Re: Planning Permission 30, Limmer Lane, Ref: FP/179/11/

Demolition of existing dwelling & outbuildings & erection of 6 no. apartments with associated parking & landscaping (re-submission following FP/182/10/)

30 Limmer Lane Bognor Regis

Drawing **Proposed Apartments
Proposed Elevations**

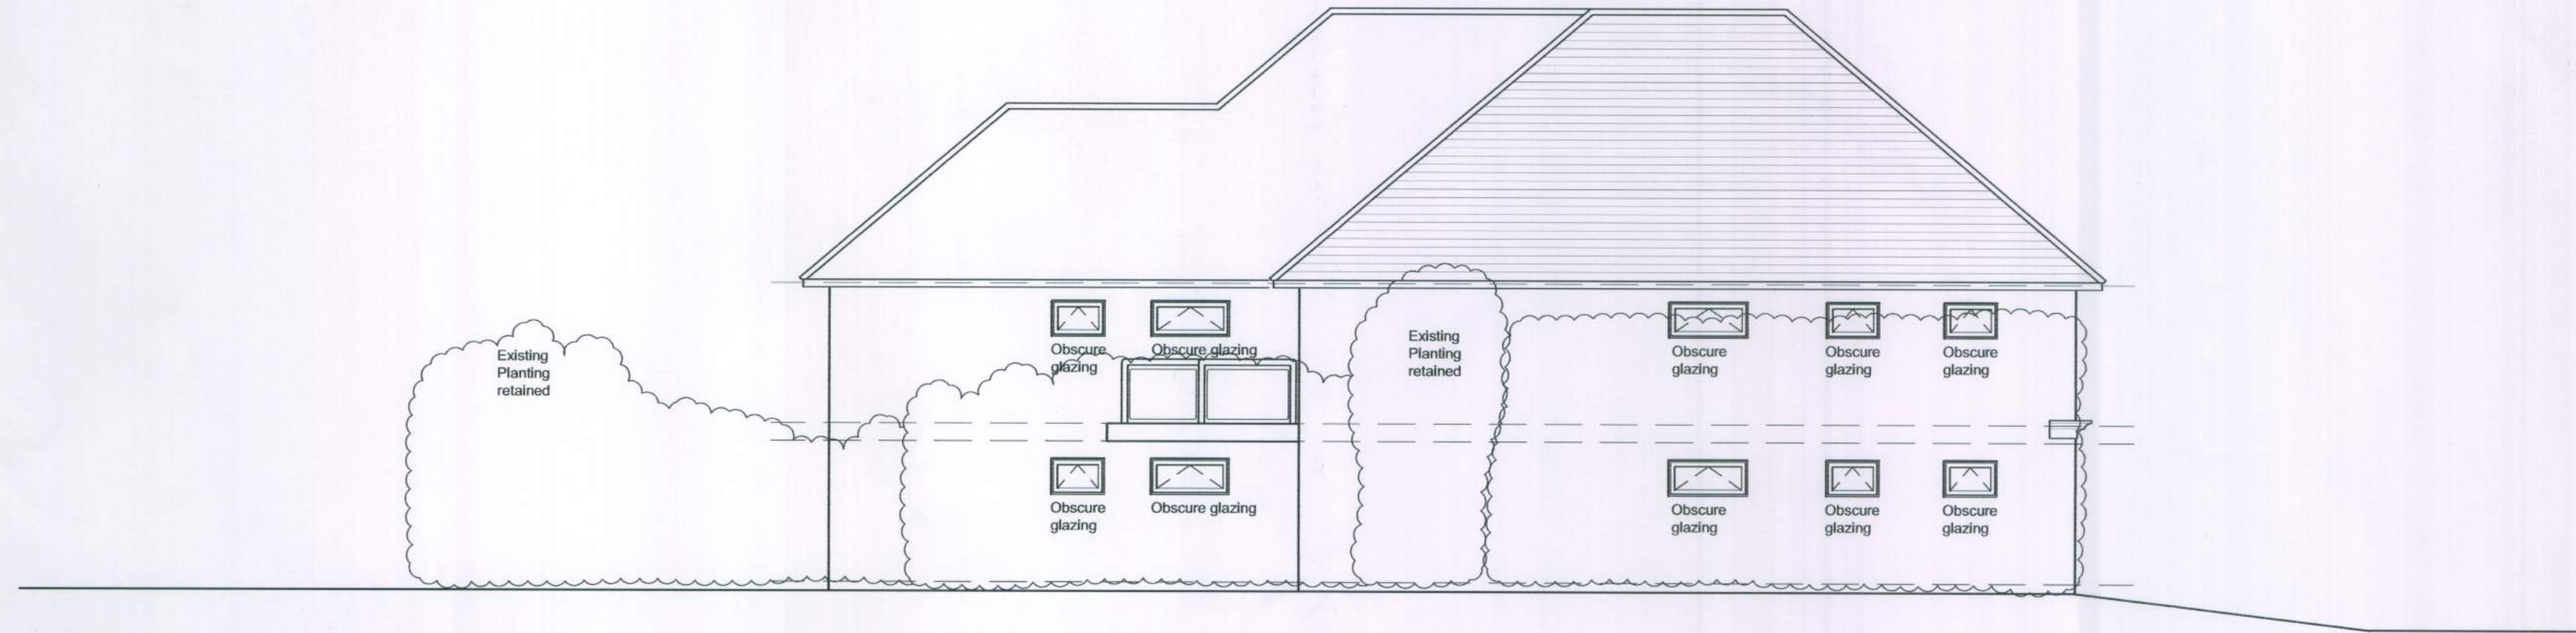
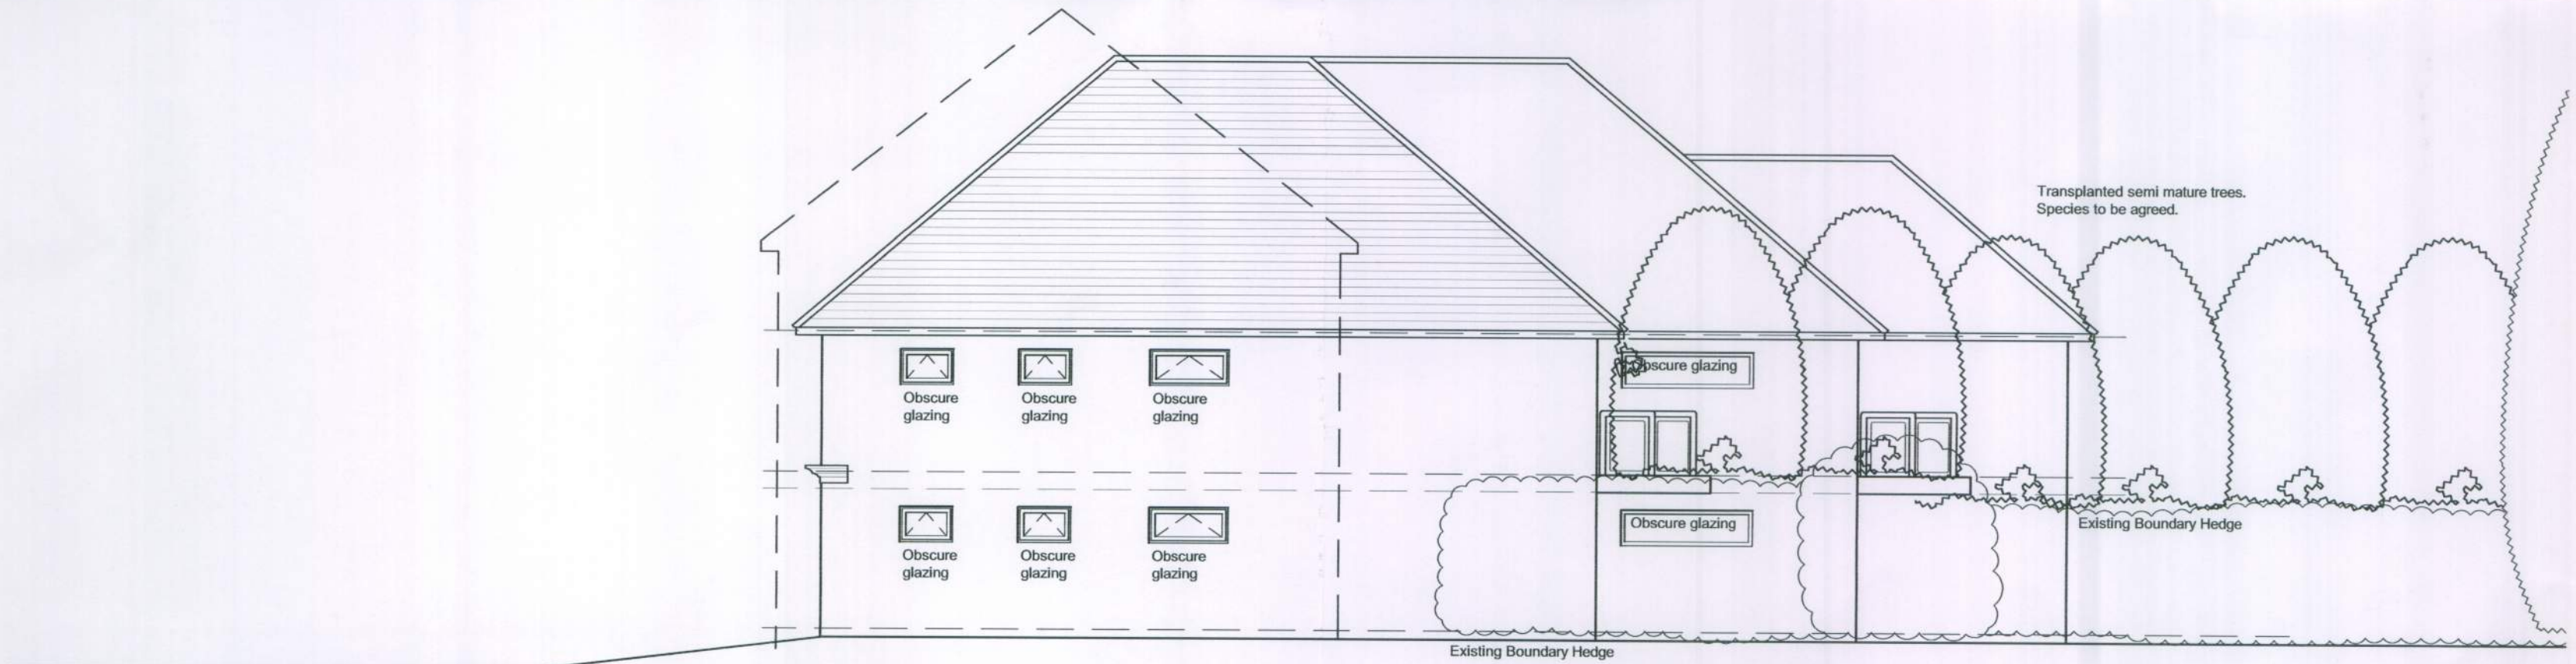
- III. **The property is "designed to visually integrate with the adjacent properties"** – no, whilst the front is designed to achieve this, the size of the development at the side and the back does not visually integrate, because it is of a disproportionate size to properties at the side and back.

- IV. **There will be "terrace or balconies"** – either would overlook neighboring properties and take away existing privacy and enable views into our sitting room and kitchen.
